**Addendum No. 1**

RE: Contract ID: C201471  
WBS# 33188.3.2  
F. A. # BRZ-1400 (4)  
Gates County (B-3640)  
Bridge over Merchants Mill Pond  
And Approaches on SR-1400.

**September 19, 2006 Letting**

NOTE:
PLACE RIP-RAP TO MATCH EXISTING SLOPES IN EMBANKMENT AND STREAM BED.

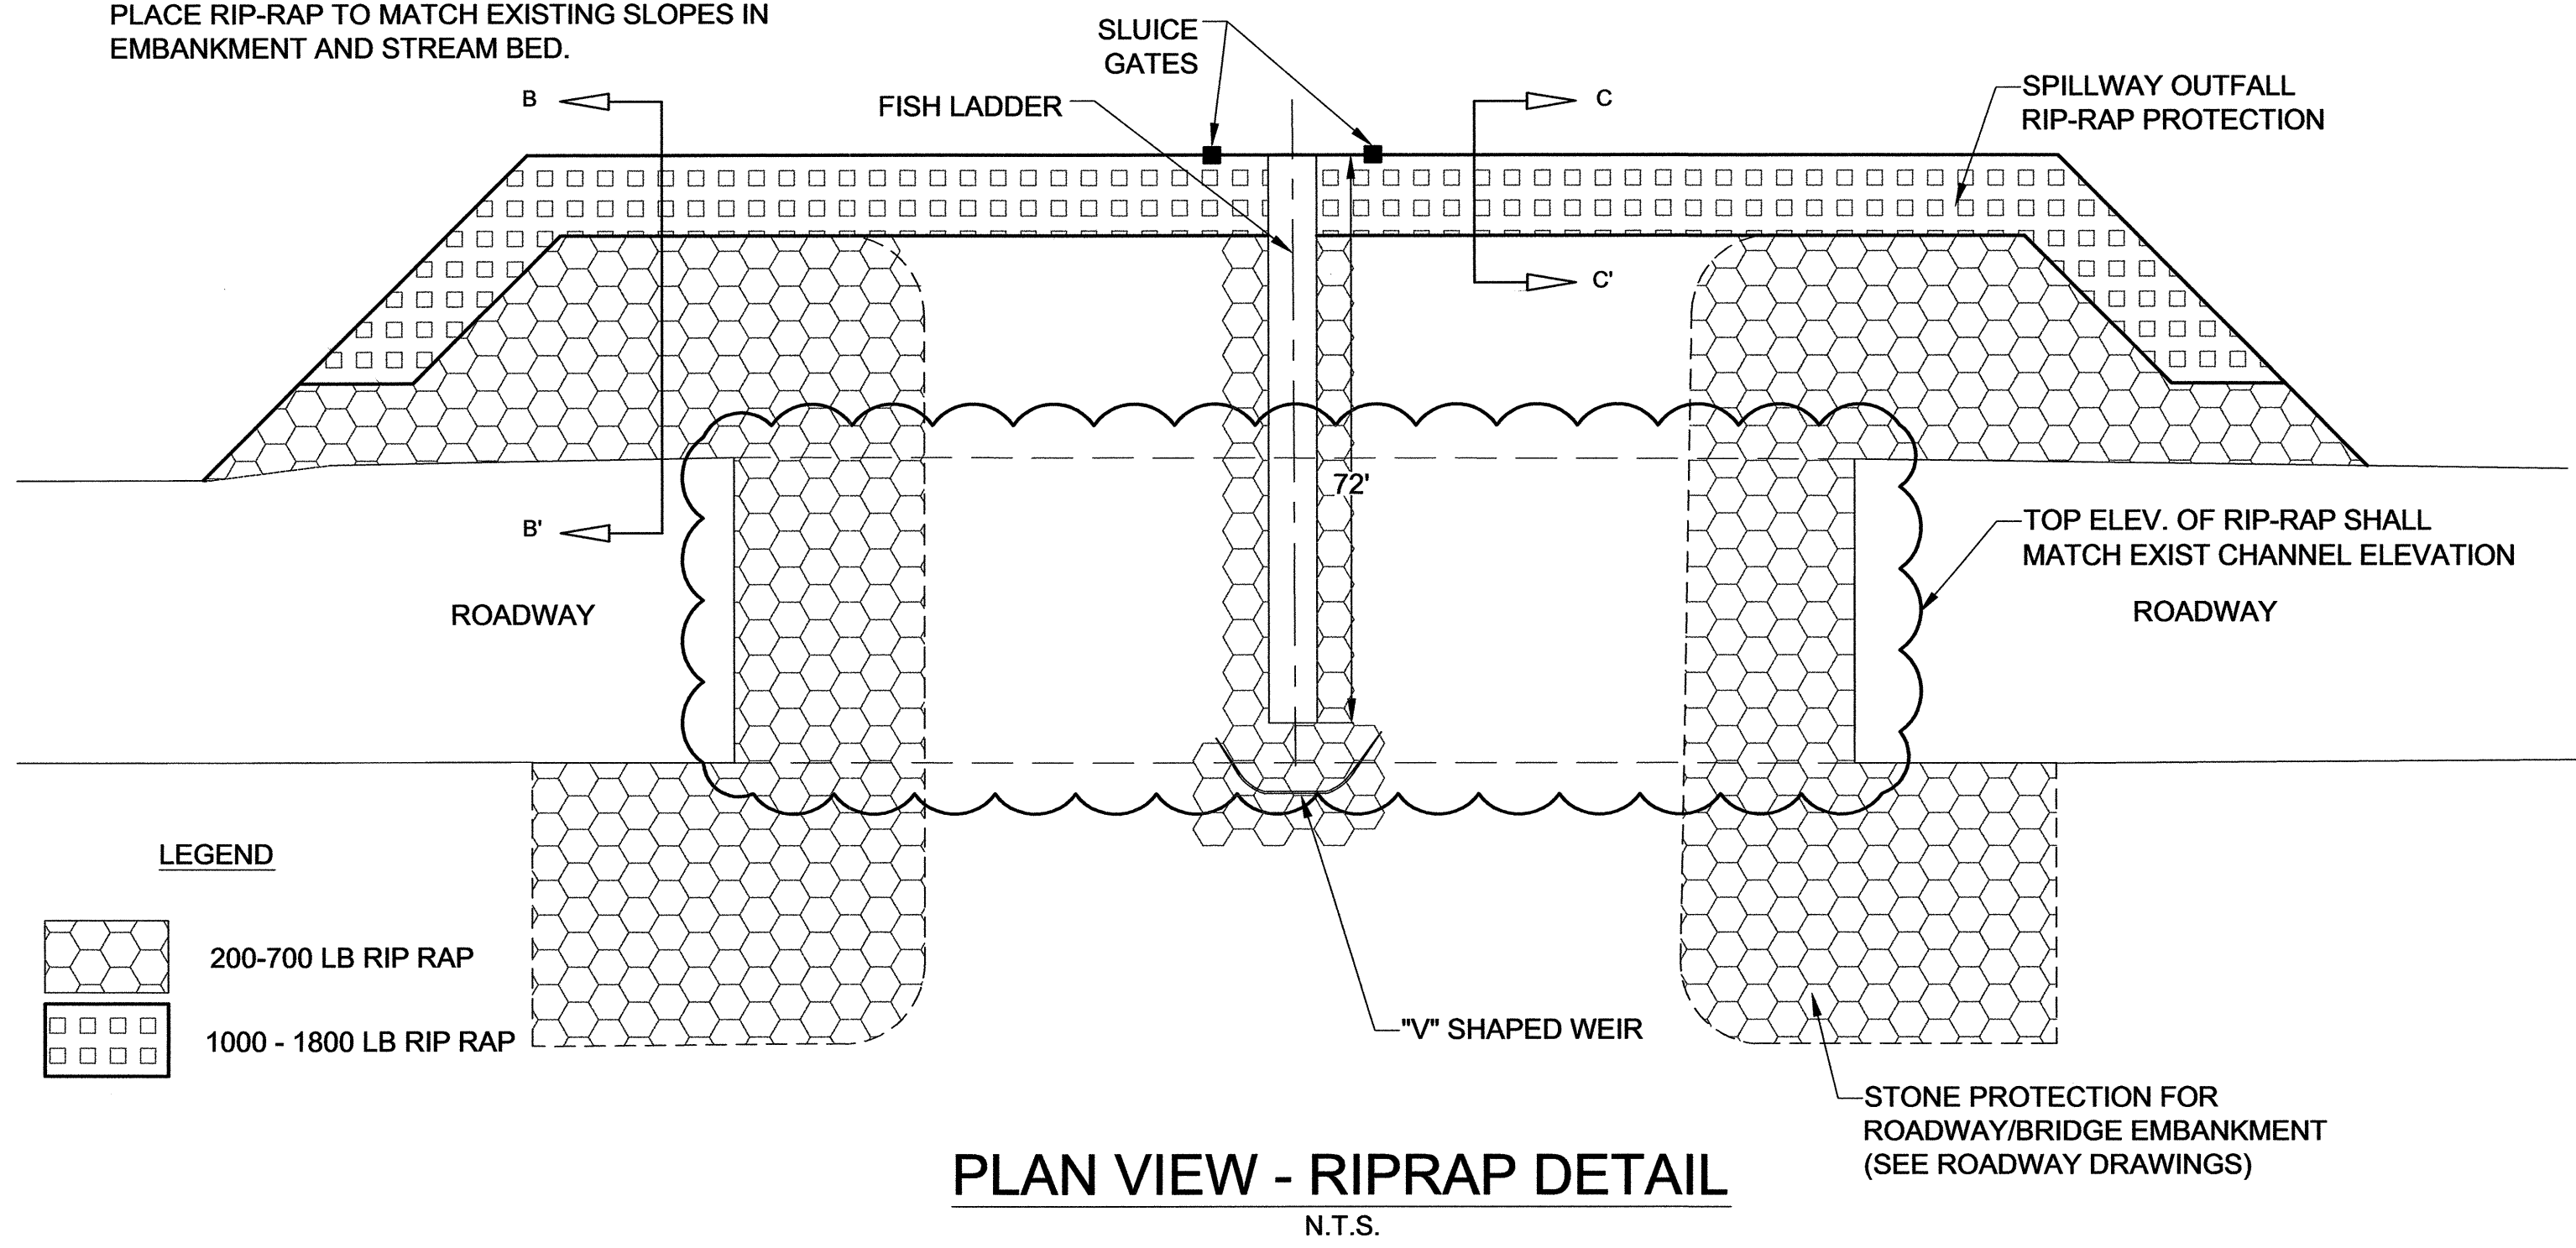
Sheet Nos. S-31, S-32 and S-33 have been revised to make changes to the fish ladder and to add details of a sluice gate platform. Please void Sheet Nos. S-31, S-32 and S-33 in your plans and staple the revised Sheet Nos. S-31, S-32, S-33 and new Sheet Nos. S-33A and S-33B thereto.
